Loreto Normanhurst School Redevelopment (Concept Proposal and Stage 1) (SSD-8996)

Response to Submissions

Drawing Title
STAGE 1 WORKS

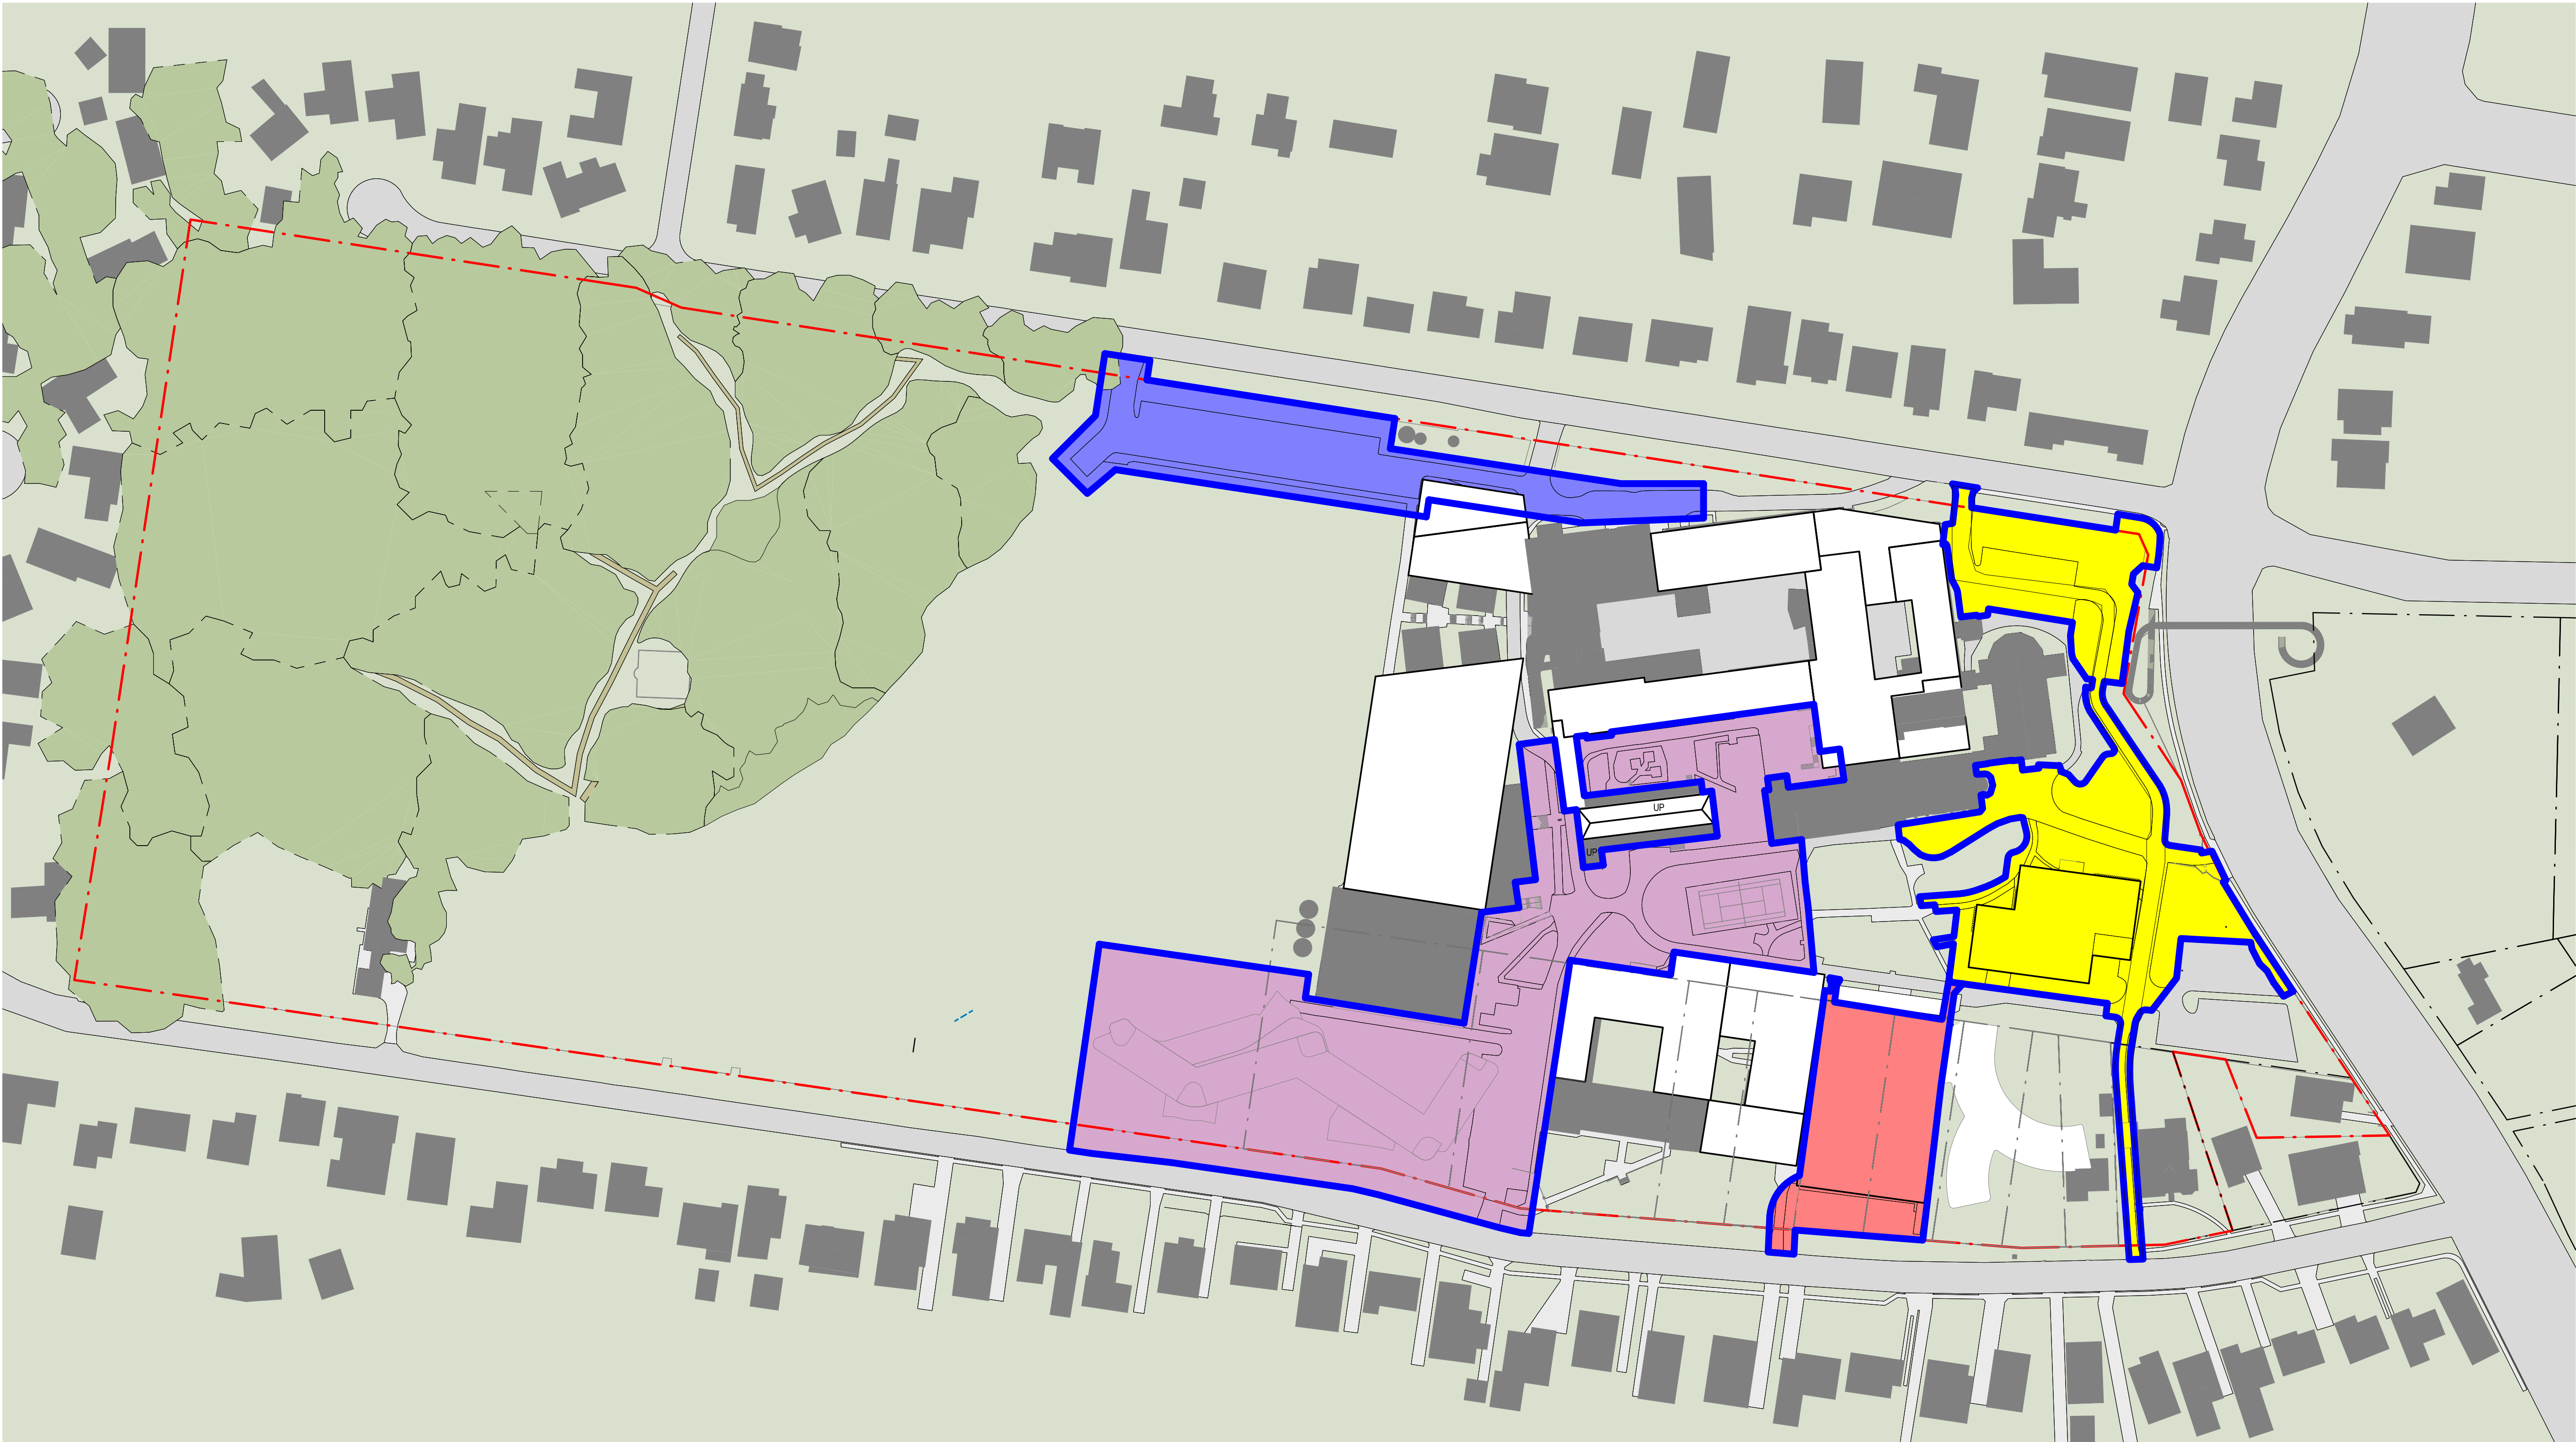
- Please provide a single 'Staging Plan' for the Stage 1 works (to include the construction sub-stages) with stage boundaries outlined (including buildings, infrastructure and landscaping works) and provide an estimate of construction timing (how many years) for each sub-stage of the Stage 1 works.
- Please confirm the timing and phasing of the following works within Stage 1:
 - landscaping works.
 - Boarding Accommodation building.
 - the bus bays (located in place of the two current pick-up/drop-off bays).
- Please confirm the location of the uniform shop during the site preparation of Stage 1 works.
- Alignment of the stage 1 works to any proposed occupation/operation/decanting staging
